January 10, 2020

**SUBJECT: Monument Academy – Site Development Plan
Response to County Planning Review Comments
PPR-19-009**

This letter provides responses to the remaining review comments detailed in the PCD Project Manager Comments posted on EDARP on 9/11/19. These review comments are specifically addressed as follows **(Applicant responses are annotated in bold / blue / parenthesis following each County comment):**

ES1

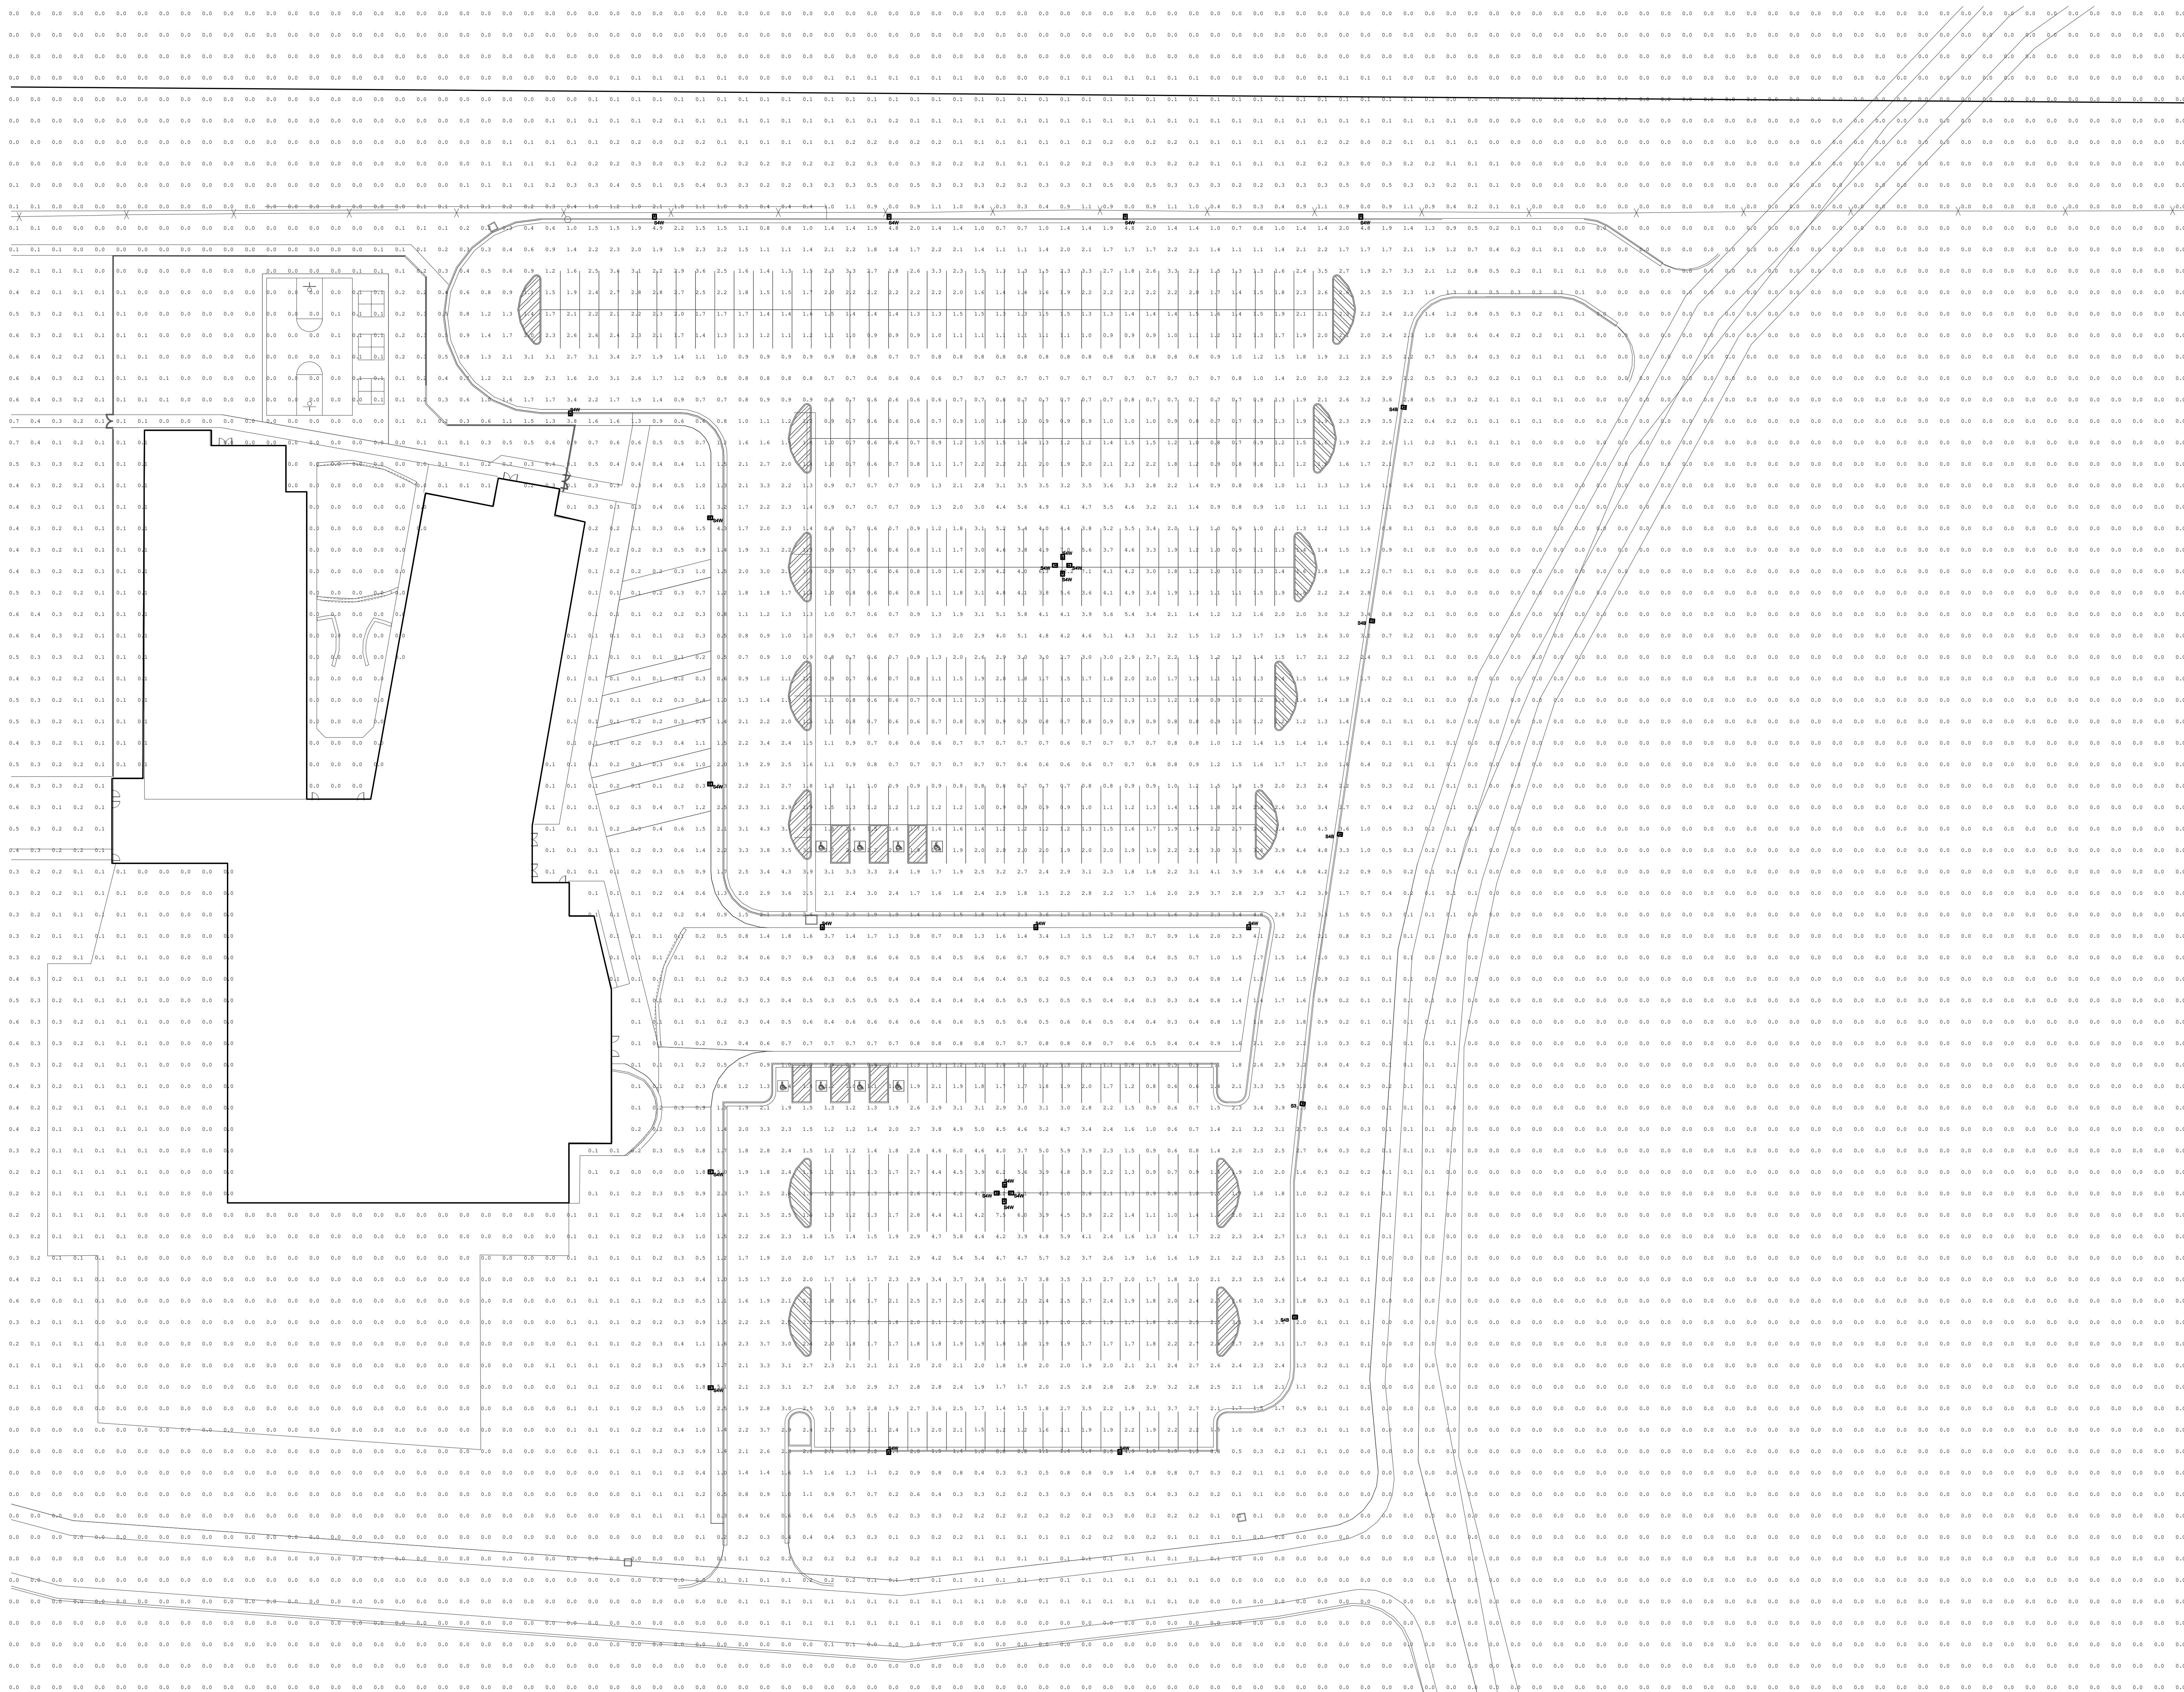
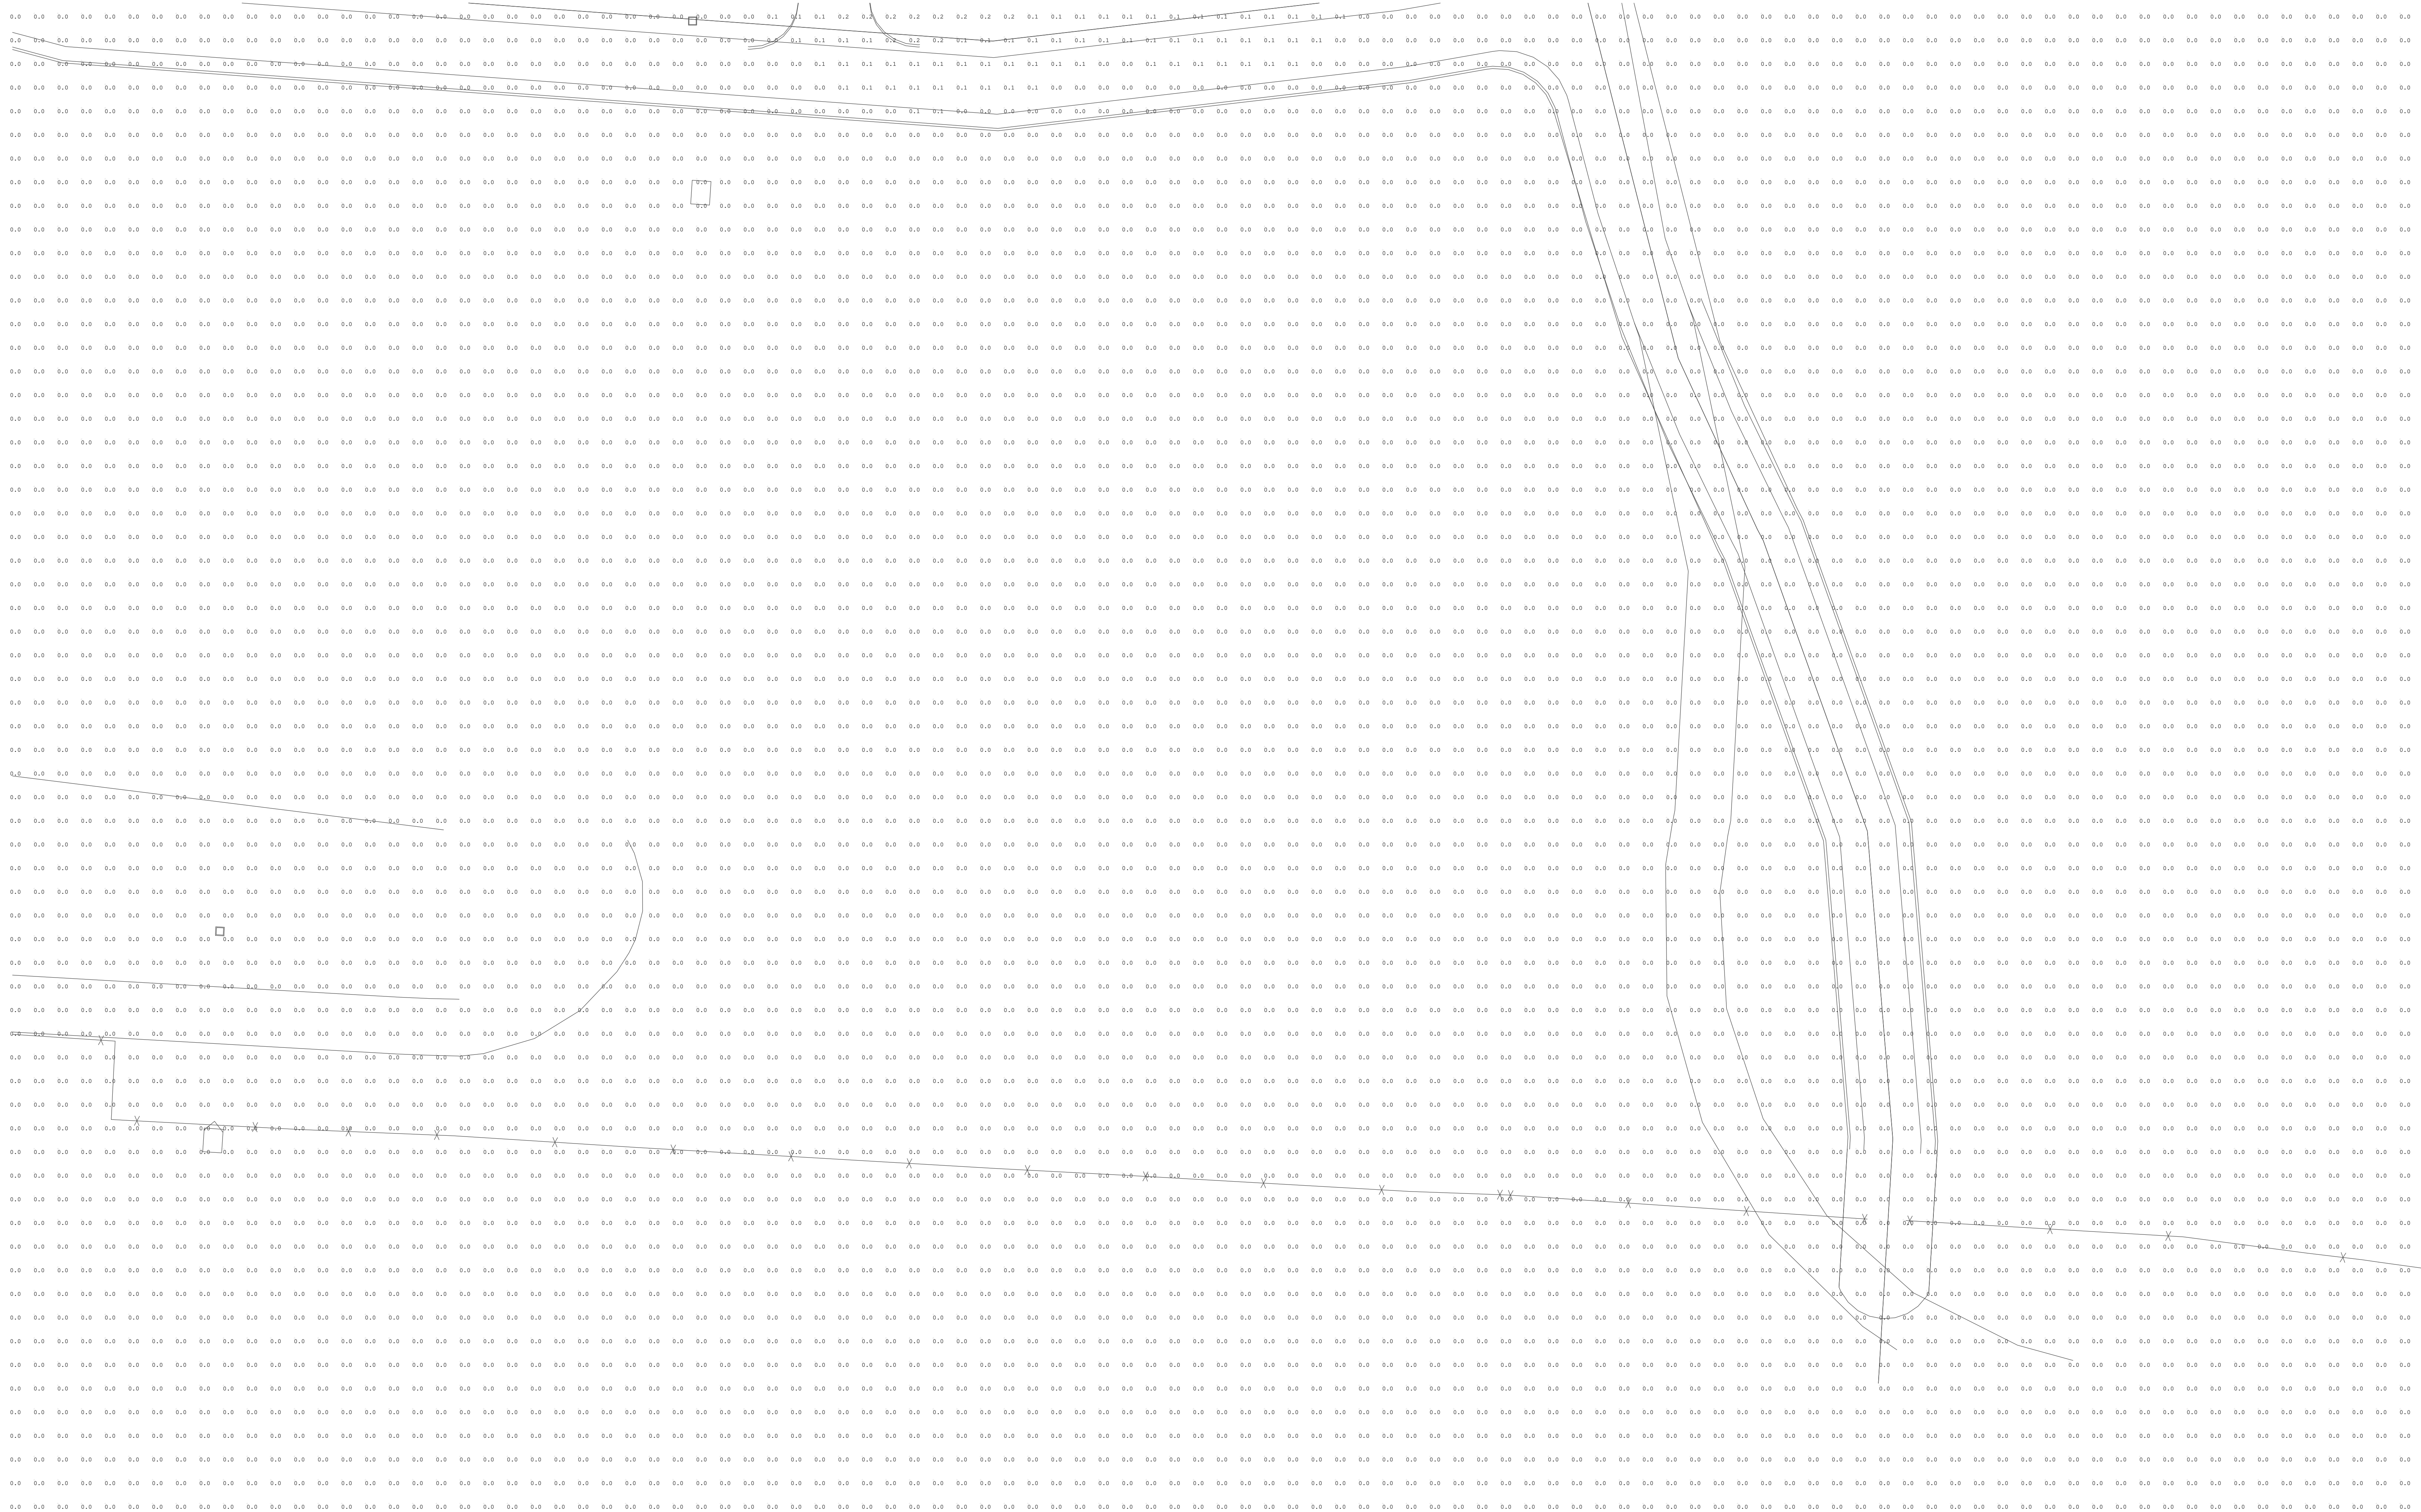
3. Please provide elevation drawings/details of the proposed freestanding lights to verify the height. **(Provided on lighting plan)**
4. The site development plan still reflects a school parcel vs. Walden parcel as well as proposed ROW/easements. The site development plan cannot include any future platting or boundary line adjustment that has not yet taken place or been applied for. **(The SDP does not include any future platting or boundary line adjustments.)**
